KIRKLEES METROPOLITAN COUNCIL INVESTMENT & REGENERATION SERVICE

Reference No:	2021/60/94410/W
Site Address:	land at, Olney Street, Slaithwaite, Huddersfield, HD7 5EG
Description:	Outline application for erection of residential development
Recommending Officer:	Ellie Worth

DECISION – Refused

Officer report

Site Plan 1:500

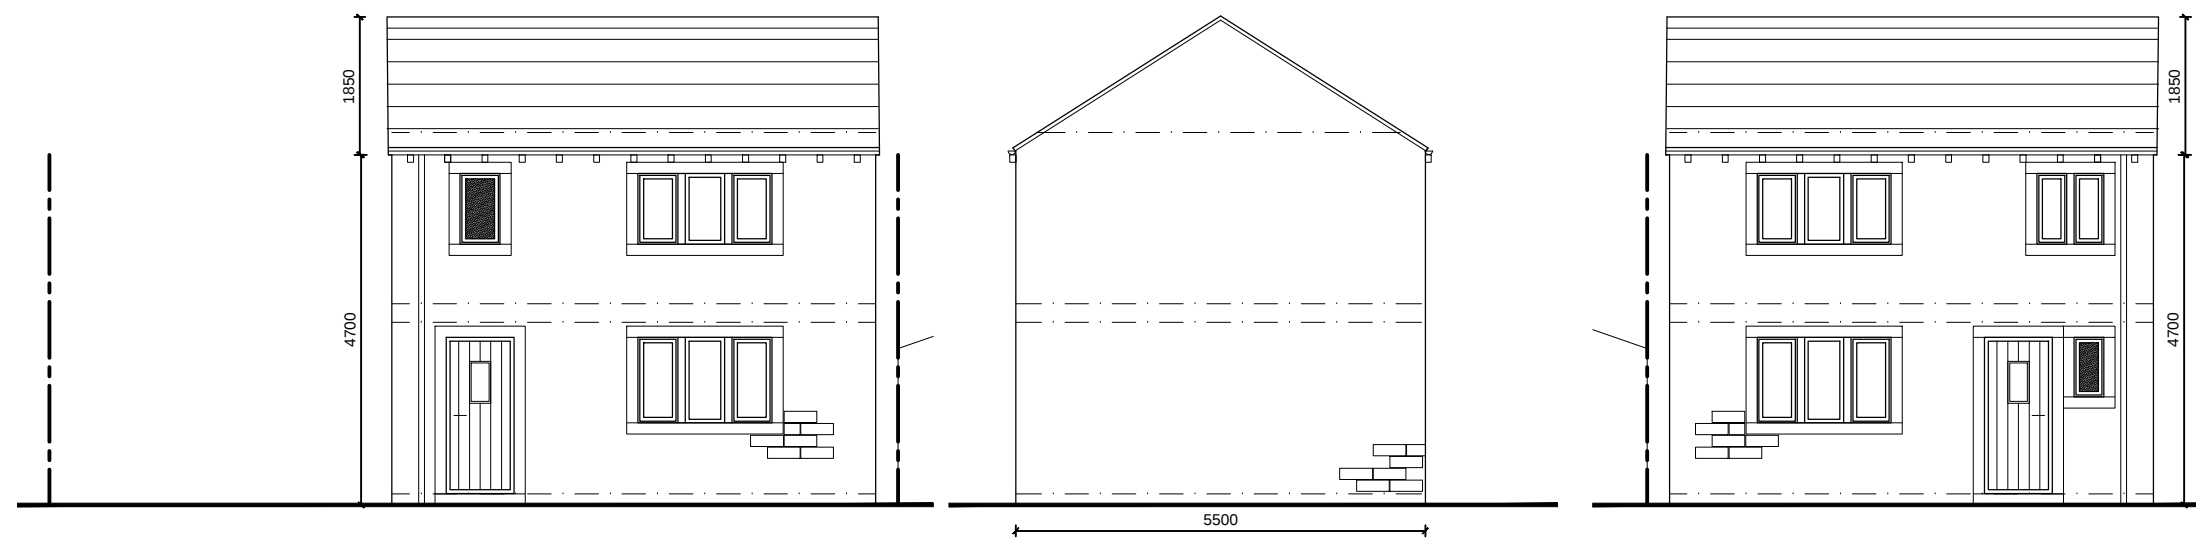
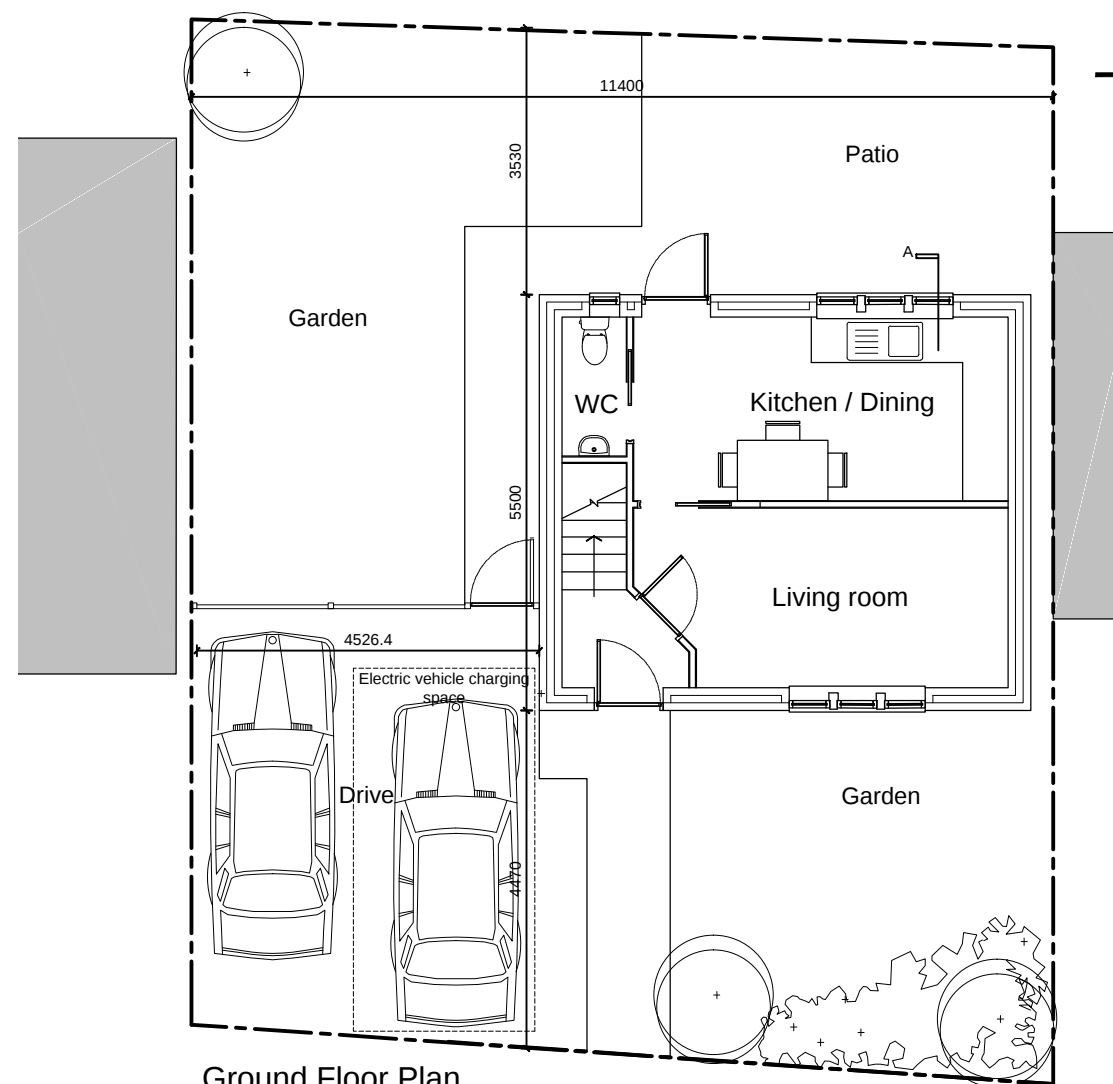
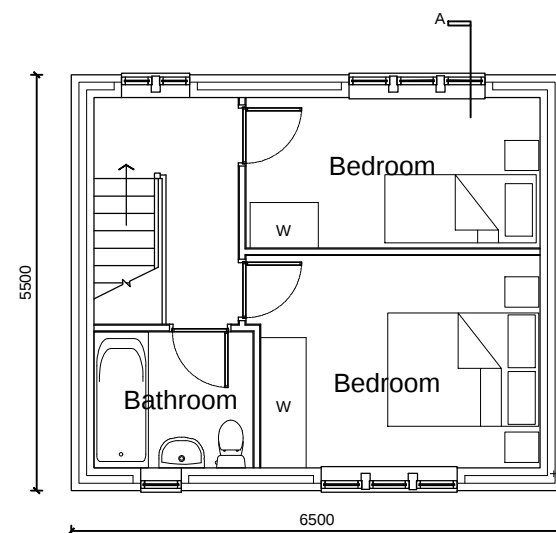
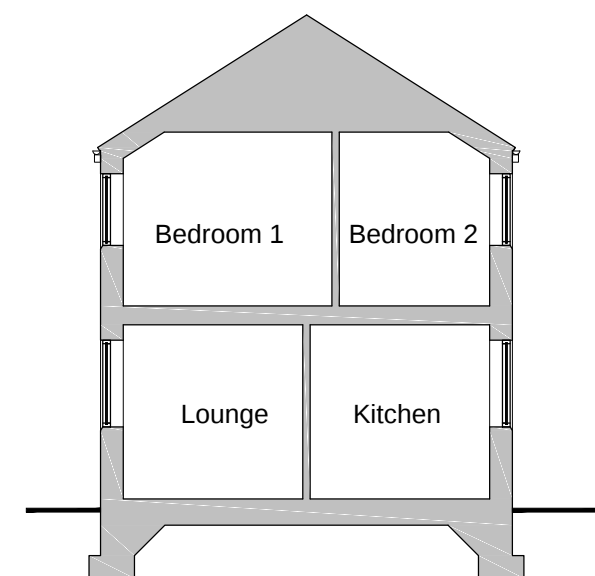
The application site is 150 square metres in size, which is considered to be limited for a two storey 2 bedroom dwelling which needs to provide off street parking. Therefore, there is concern that the plot is of an insufficient size to accommodate a detached dwelling. An indicative layout plan has been provided to demonstrate how the plot could be developed, and it is considered that this would be the most likely arrangement to achieve access and parking for the dwelling, whilst still retaining a level of outdoor amenity space.

There are concerns with the layout proposed and it is considered that there would be similar concerns with other layouts put forward given the limited size of the plot. With regards to the indicative scheme, the dwelling shown has an internal floorspace of 62 sq.m, which would fail to meet the technical space standards for such a dwelling, where at least 70 sq.m should be provided, to achieve this increase in dwelling, would require a greater footprint and further development of the already small plot. The parking spaces shown are also of insufficient width, where they are shown to be 4.5 metres wide and would need to be ideally 6.4 metres wide to be workable as detailed in the highway section of this report, increasing the parking area would further develop the plot. In addition, as set out within the Highways section of this report, the

submitted layout does not detail the provision of a 2 metre wide footway as would be required to make the scheme acceptable in highway terms, or even the existing footway which is evident on site. Providing the footway would further reduce the developable area of land again and make the proposed parking layout further unworkable. Furthermore the dwelling is shown to be within 0.25m of the north eastern boundary, where Officers would normally expect at least 1 metre to be achieved to allow sufficient space around the dwelling. Finally the depth of amenity space provided to the rear would be severely restricted at 3.5 metres depth.

Whilst officers acknowledge that the plans submitted as part of this proposal are indicative with regards to appearance, the development proposes a two bedroom dwelling in which would have an internal floor space of 62 sq.m. This is significantly below the Governments 'Technical Space Standards' which sets out that a dwelling of this size should have an internal floor space of 70 sq.m. As such, the development would be contrary to the aforementioned guidance document and Paragraph 9.1 of the Councils Housebuilders Design Guide. This therefore demonstrates that an appropriate level of amenity cannot be achieved at the site, in a way that doesn't result in the overdevelopment of the plot.

1. There is no kerbed footway to the site frontage and a 2.0m wide footway should therefore be shown to be provided.
2. The size of the parking spaces is too small at to 4.5 in width and 4.4m in depth. Parking spaces should be 3.2 m in width x 5.0m in length
3. Bin collection points should be provided to enable bins to be presented on collection day without either obstructing the highway or proposed driveway.
